Please find attached the latest revised version of the drawing for the proposed Garage that refers to the proposed replacement tree to the SE corner of the site, approved under application reference R/271/19/T.

Further to our discussions, please find attached a revised garage design which incorporates the following:

183038/ 05B

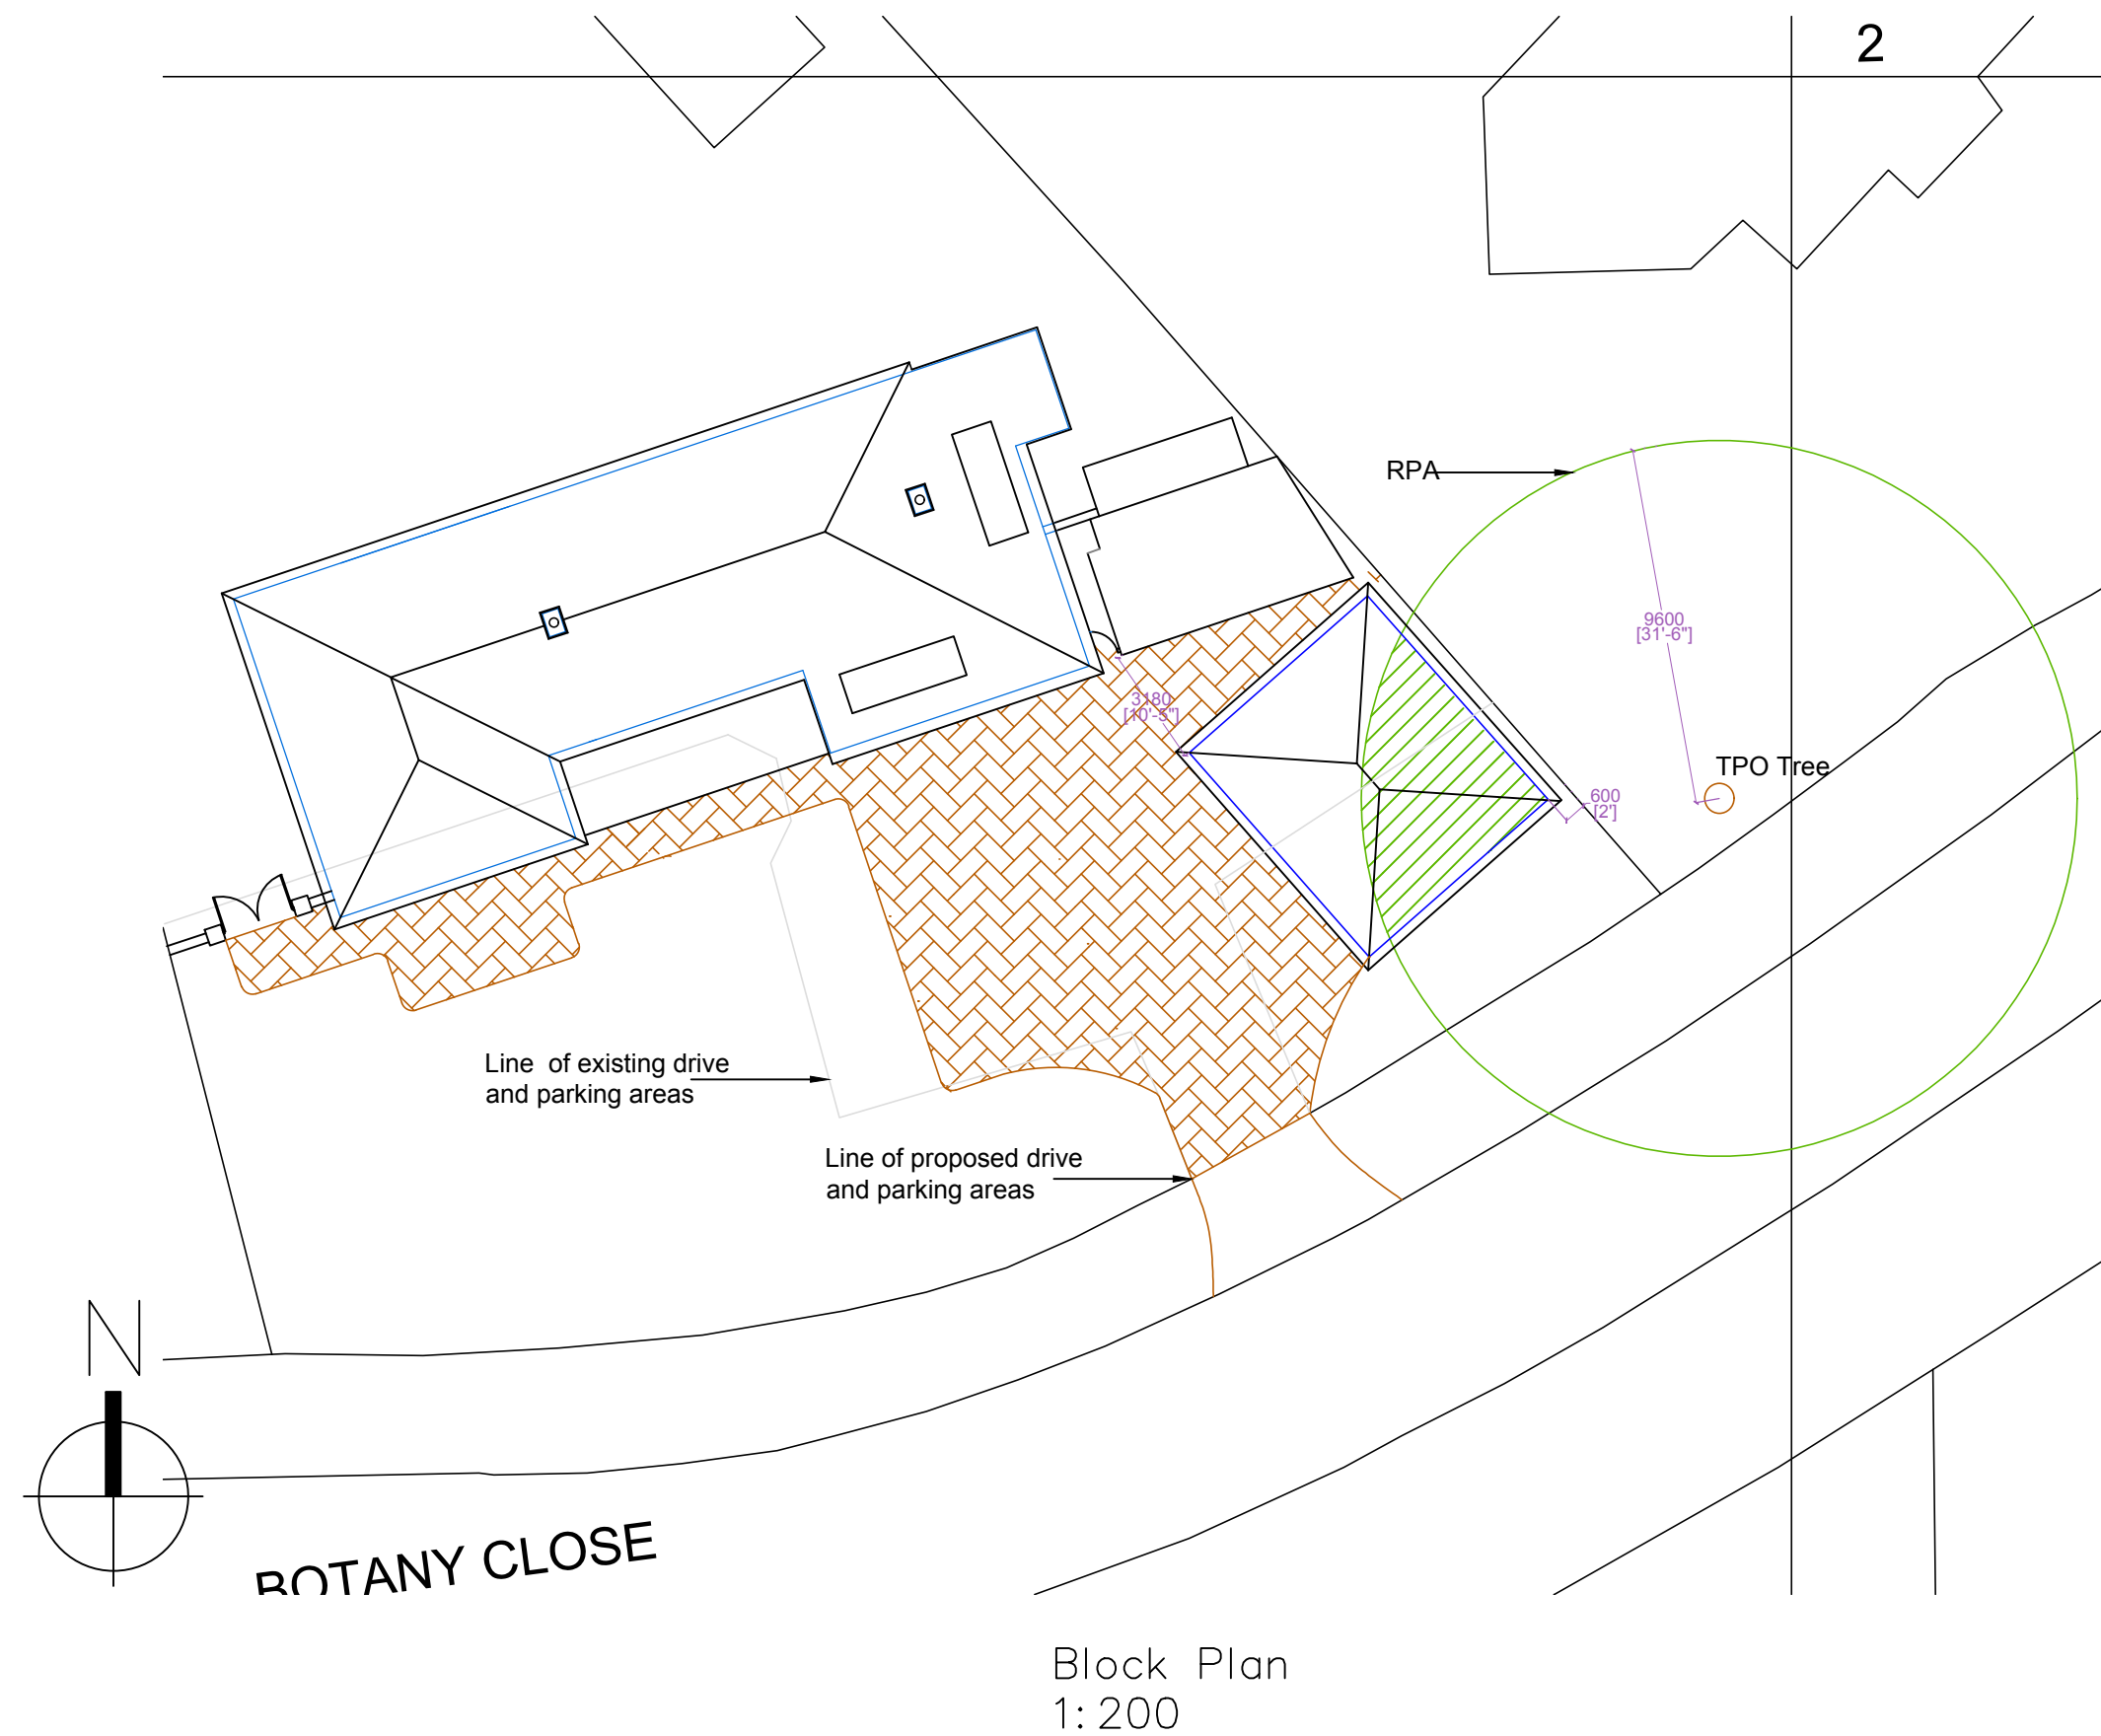
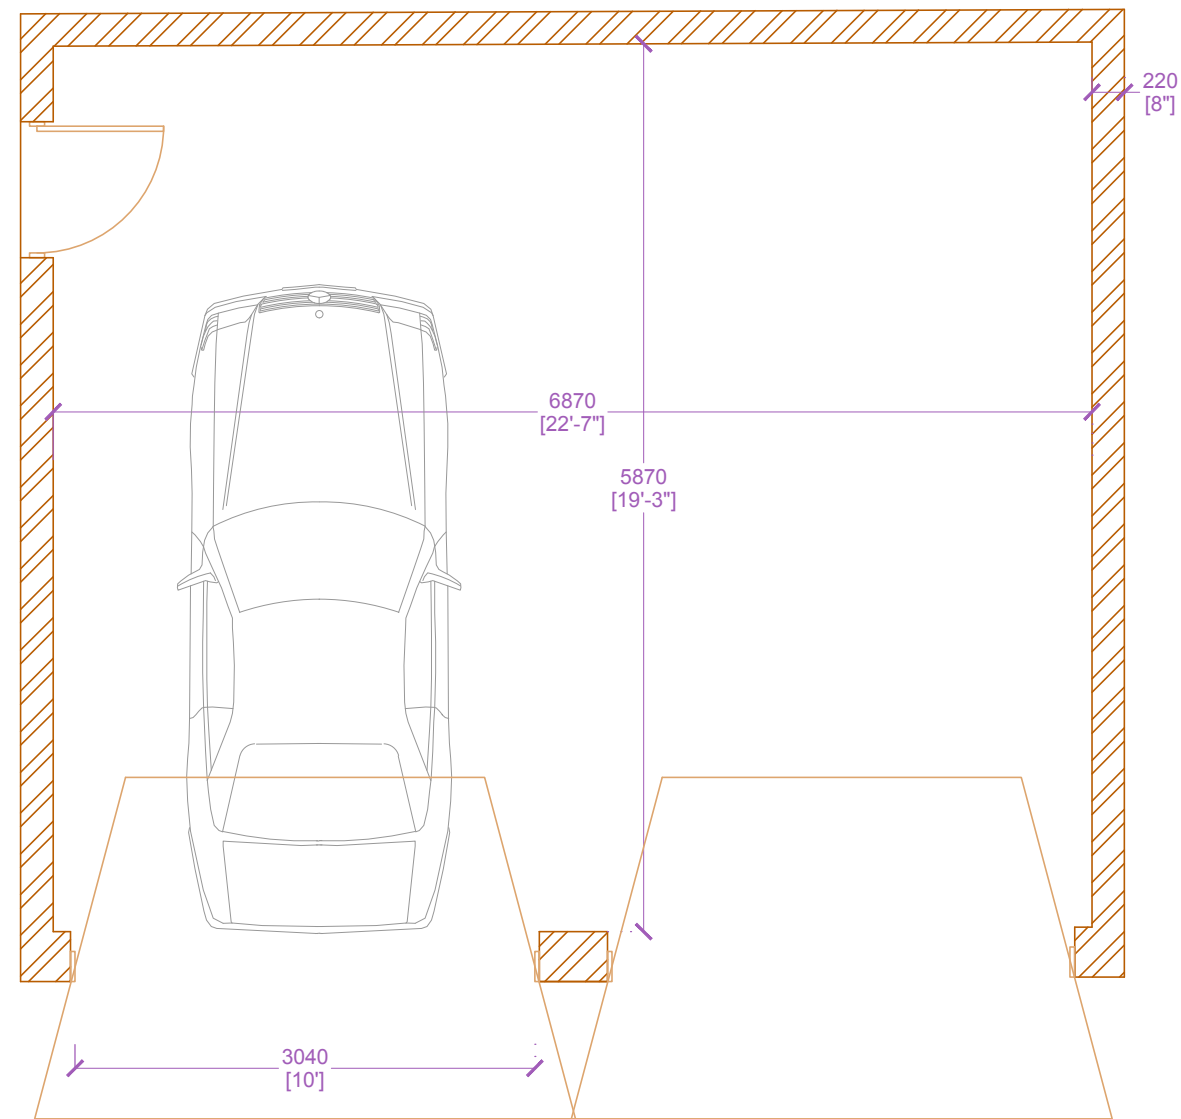
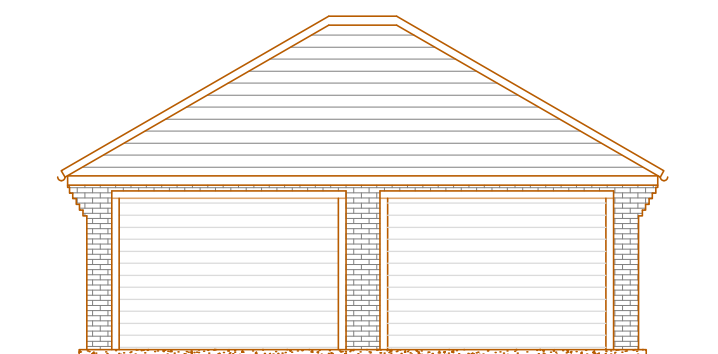
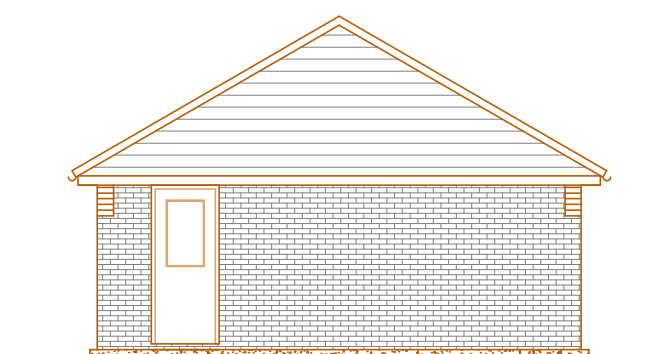
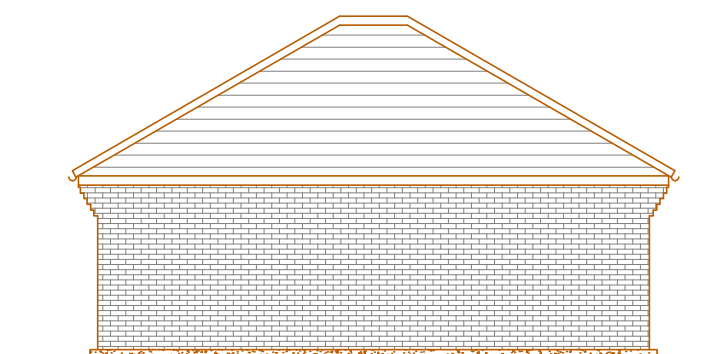
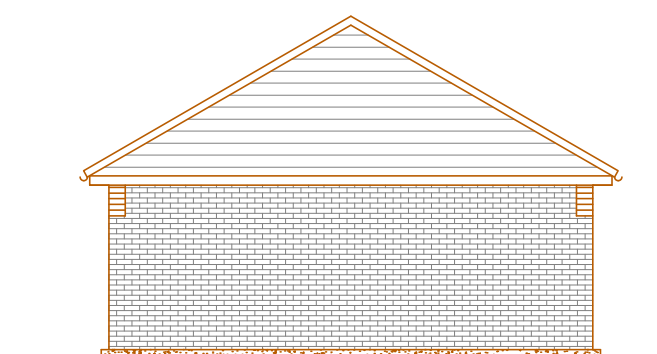
The view of the Planning Department is that both of the changes should be implemented (the materials, and the landscaping), as it is felt that these changes are likely to mitigate the potential for harm to the area.

Please could you confirm if now that the garage is to be visually screened by the trees if a brick wall material would be acceptable? Our client is keen for the materials to match where possible.

- 1) The pitch of the roof has been reduced resulting in a reduction in the ridge height and overall mass of the roof.
- 2) The proposed materials have been varied from facing brick and interlocking tiles to match the house, to softwood featheredge weatherboard and brown plain clay tiles, to more subtly blend visually with the surroundings.
- 3) Landscaping to the South and Eastern boundaries has been added to screen the majority of the garage, which now sits more sympathetically within the streetscape.
